Response to WSCC Strategic Planning Consultation Comments dated 6 September 2012

Proposed housing development at

**Roundstone Lane, Angmering
Arun Planning Application A/82/12**

23 November 2012

**2011 Observed Queue Lengths  
AM Peak Hour**

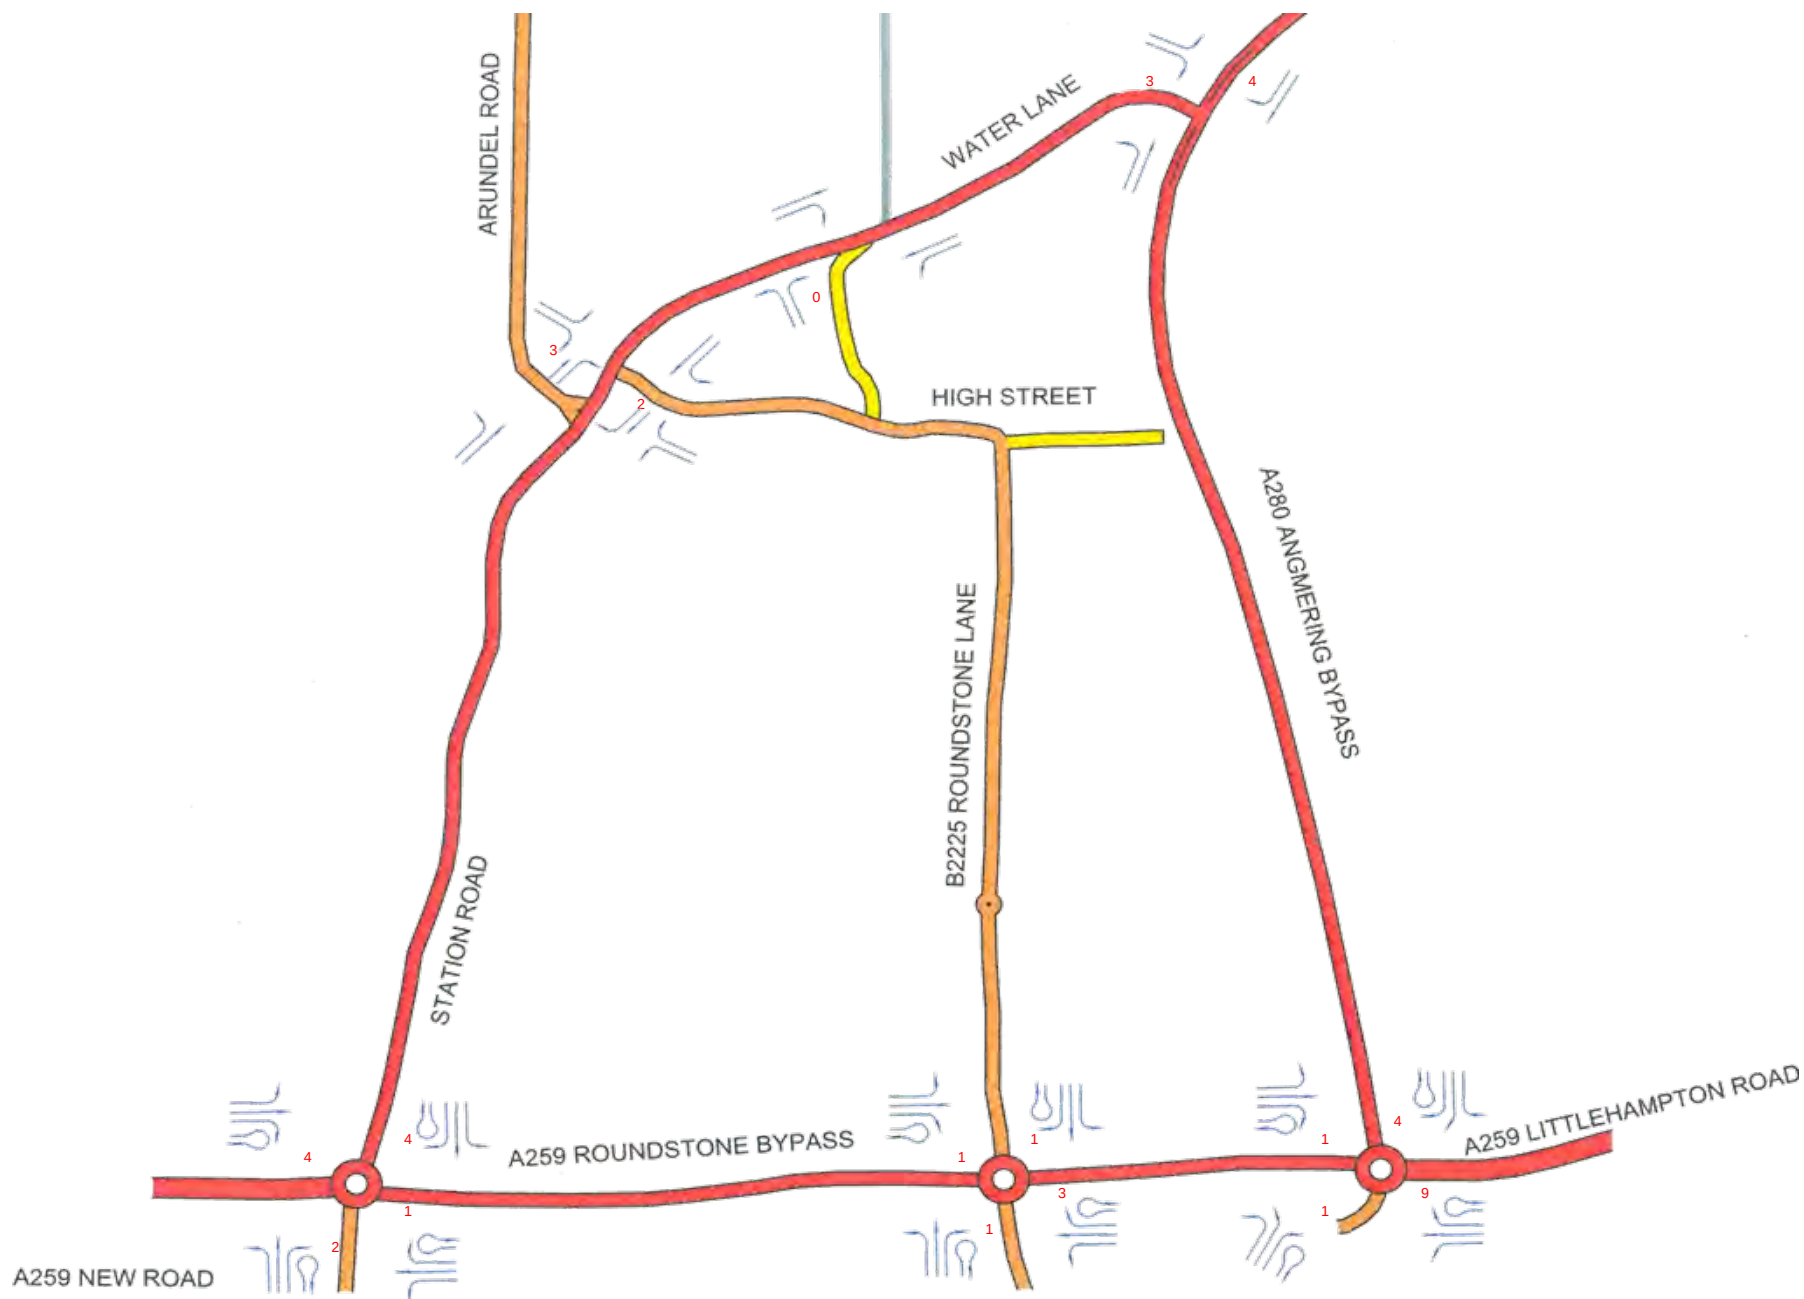
'Junction assessments: These do not appear to be consistent with observed traffic conditions on the A259 or at Water Lane/A283. The queue lengths in Appendix 11 appear to be lower than actual observed queue lengths during the morning and evening peak hours. Further detail should be provided on the junction assessments relating to the A259 to explain the relationship between observed congestion and the technical junction assessments.'

Queue length data taken during the traffic survey together with a summary in table and also schematic format is attached in Appendix 1 at the rear of this note.

The observed lengths in vehicles were noted every five minutes by the survey company. The summary queue lengths compiled by us from this data are mean average PCUs to match the definition of queue in TRL's ARCADY method. Capacity models are based on geometrical measurements taken from Ordnance Survey and aerial photograph. Percentage arm capacity adjustments have been undertaken where necessary such that the output from the ARCADY base model shows similar results.
